From: Matt Brockhurst [REDACTED]
Sent: 28 April 2021 10:35
To: Nicola Moore
Subject: RE: Request for further information BN/47/21/CLP
Attachments: PL-PR1_ProposedFloorPlan_Rev2[B].pdf

Thank you for the amended plan. On checking the measurements of the proposed extension, the proposed West elevation shows windows either side of the door, but these do not appear to be shown on the proposed floor plan.

WEST ELEVATION

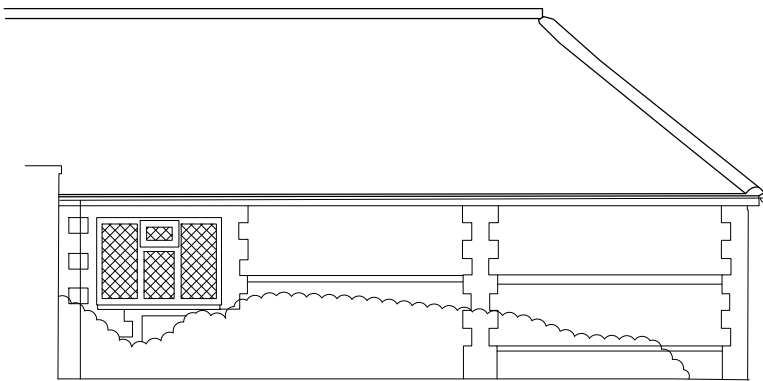
Please can you check the plans, and amend accordingly, or confirm if correct.
